The Drovers Solar Farm

Statement of Common Ground (SoCG) with Borough Council of King's Lynn and West Norfolk (Clean)

PINS reference: EN0110013

Document reference: APP/5.20.2 (Revision 2)

The Drove, Swaffham Solar DCO	PROJECT
Ground Nesting Bird Strategy	TITLE
6806/GNBS2	DRAWING NO.
A/DO	REV
September 2025	DATE
LP/DO	QC

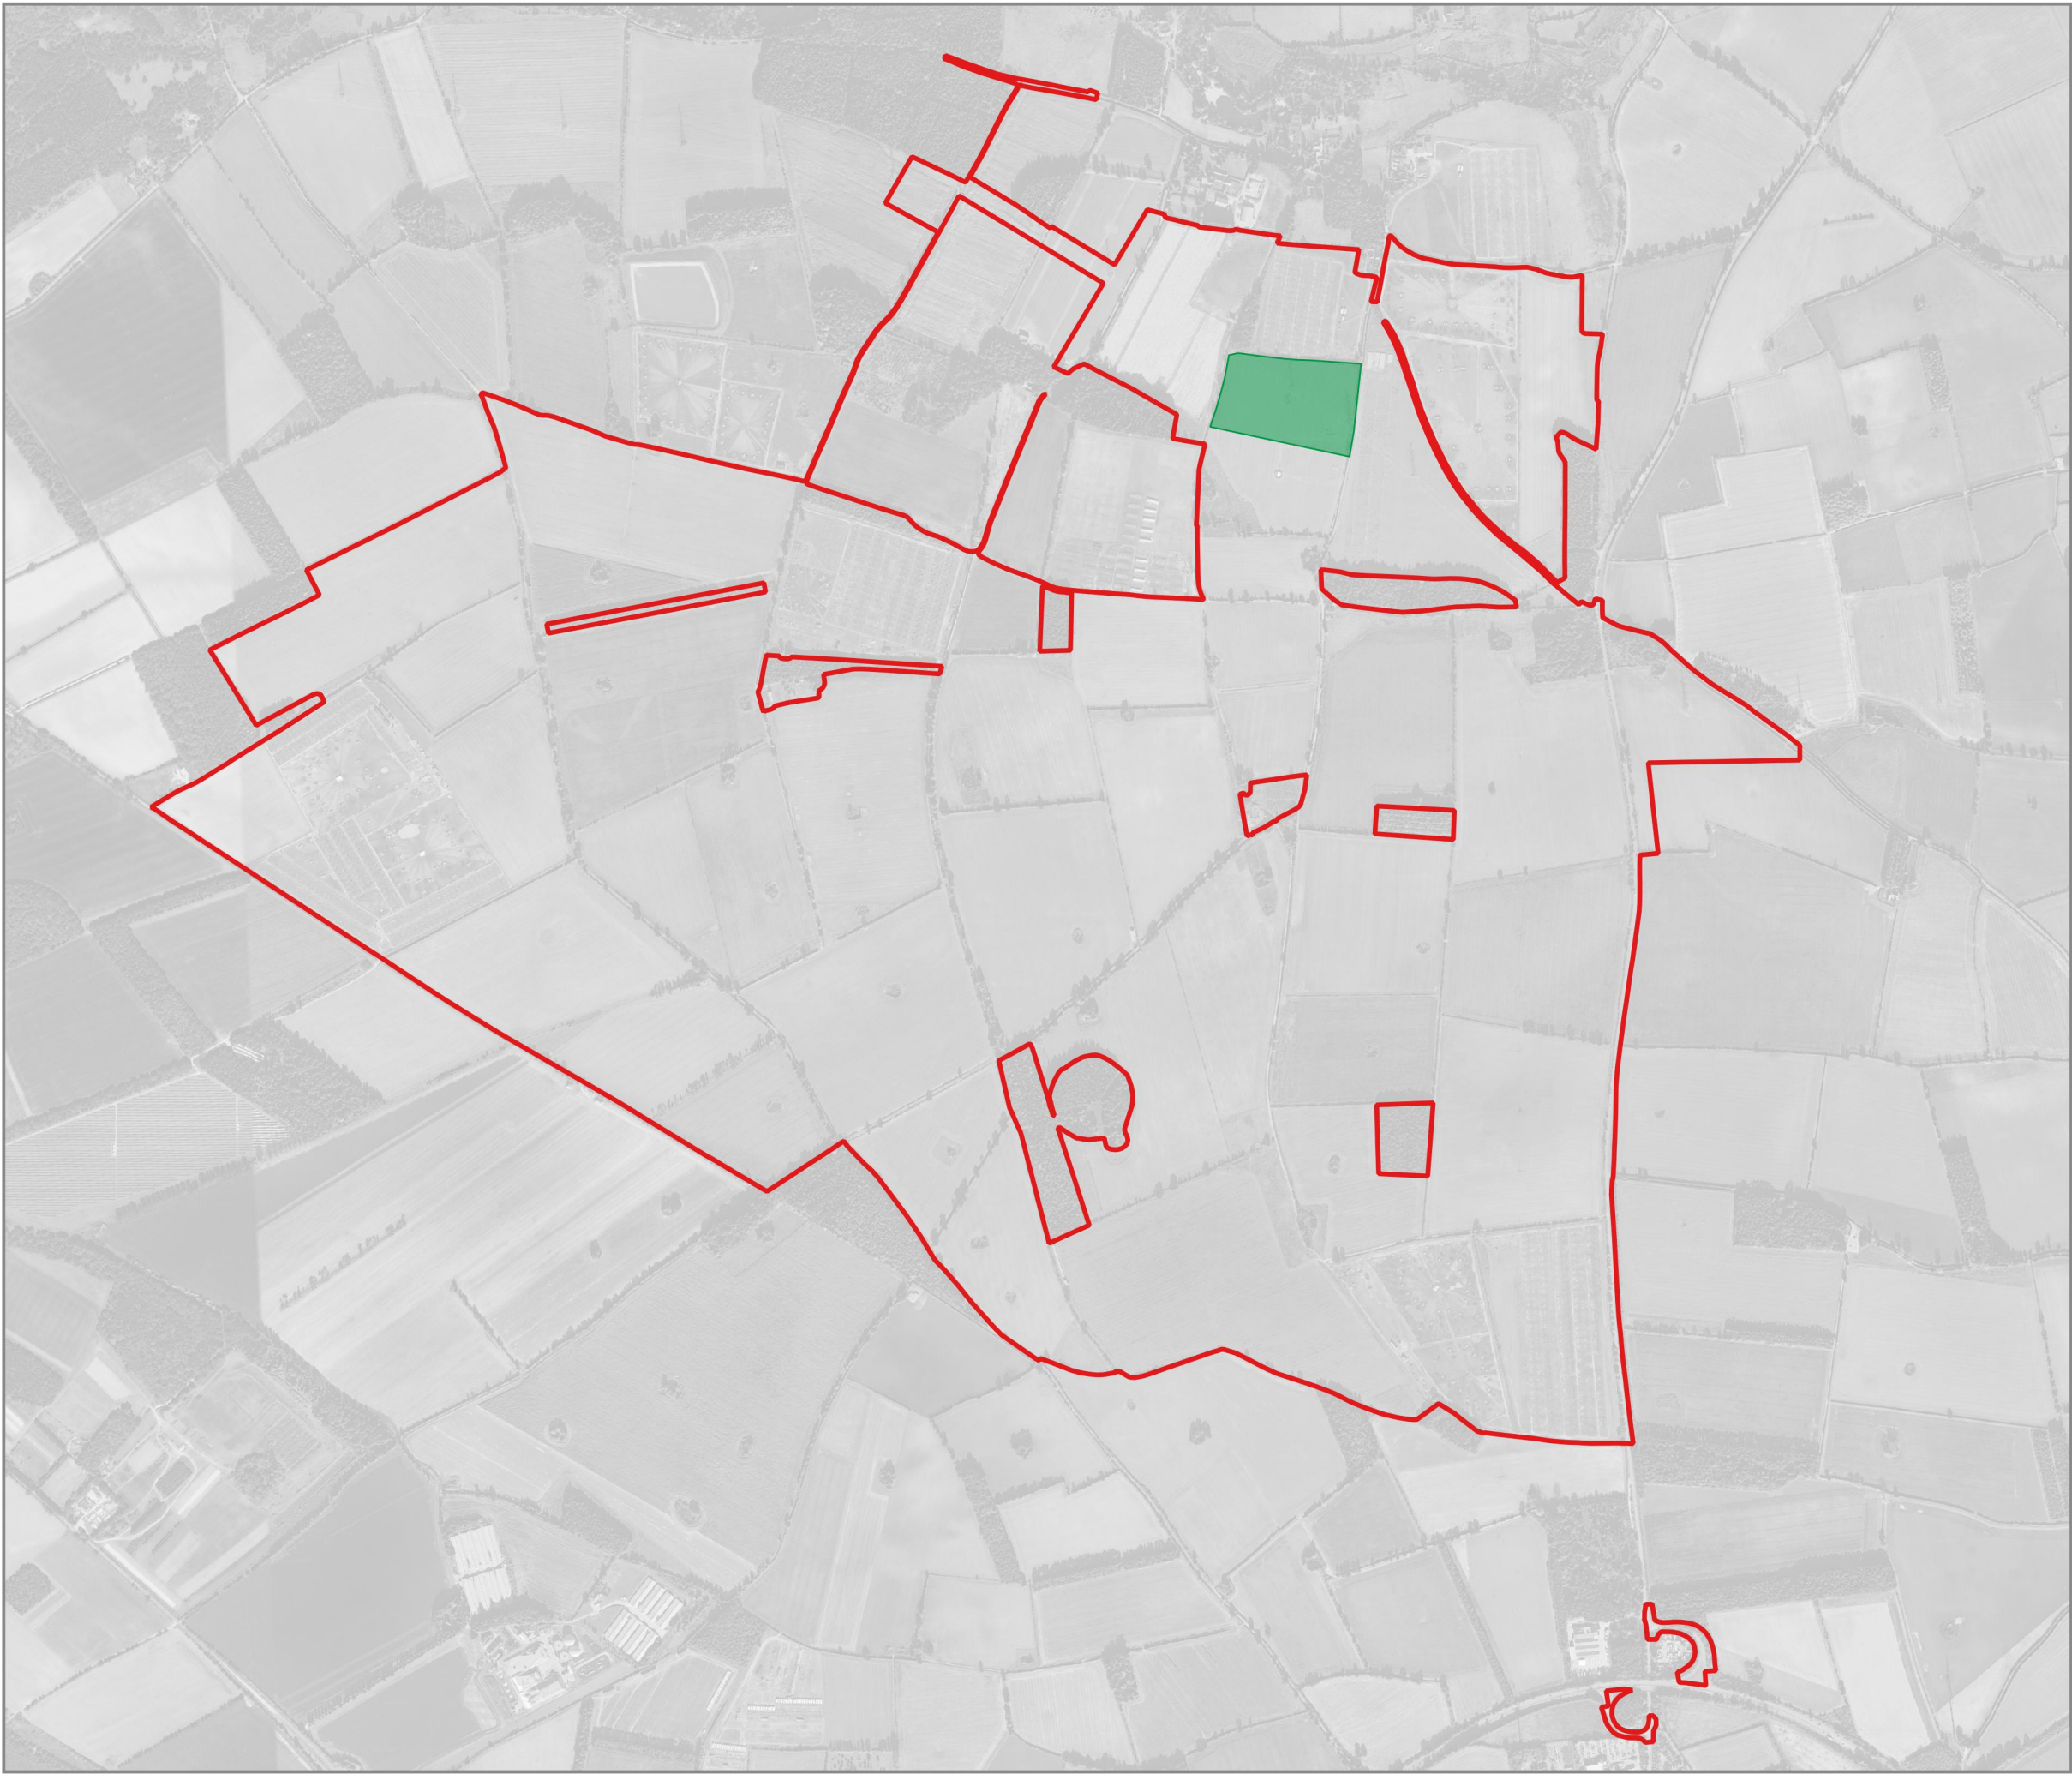
KLWN 3-3	Badgers	On the basis of fencing retaining key wildlife corridors in the field margins, no significant adverse impact has been identified on badgers.	This is noted by the Applicant	Agreed
KLWN 3-4	Wintering Birds	The magnitude of impact on wintering bird populations would be negligible.	This is noted by the Applicant	Agreed
KLWN 3-5	Skylark Mitigation	The Council raise concerns regarding the methodology behind the plots provided for skylark mitigation at points 3.3.7 and 3.3.8	As set out within the ES Appendix 7.3: Proposed Mitigation Strategy for Ground Nesting Birds Requiring Open Habitats [APP-149] , the	Under Discussion

of the Local Impact Report [REP1-076] . The Council note that this point is under discussion whilst their ecologist considers further.	methodology used in relation to calculation of Skylark mitigation follows the approach set out within published methodology (Fox, 2022). As set out, the initial input figure of 117 pairs has been used in relation to the development footprint (i.e. excludes the 4 pairs within field 32 which is outside of the Scheme's boundary but includes the existing pairs within fields 33 and 35 and as such these are taken into account). In relation to territories that could be absorbed within 75m of the development edge habitats, in line with the published methodology this relates to an increase in capacity over the existing use due to increased foraging habitat in proximity to the edges of the development and accordingly, the exclusion of the existing pairs within field 32 from the calculations is no different from that within surrounding fields elsewhere, which would be anticipated to support a baseline of Skylark usage, and therefore consistent with the published methodology.
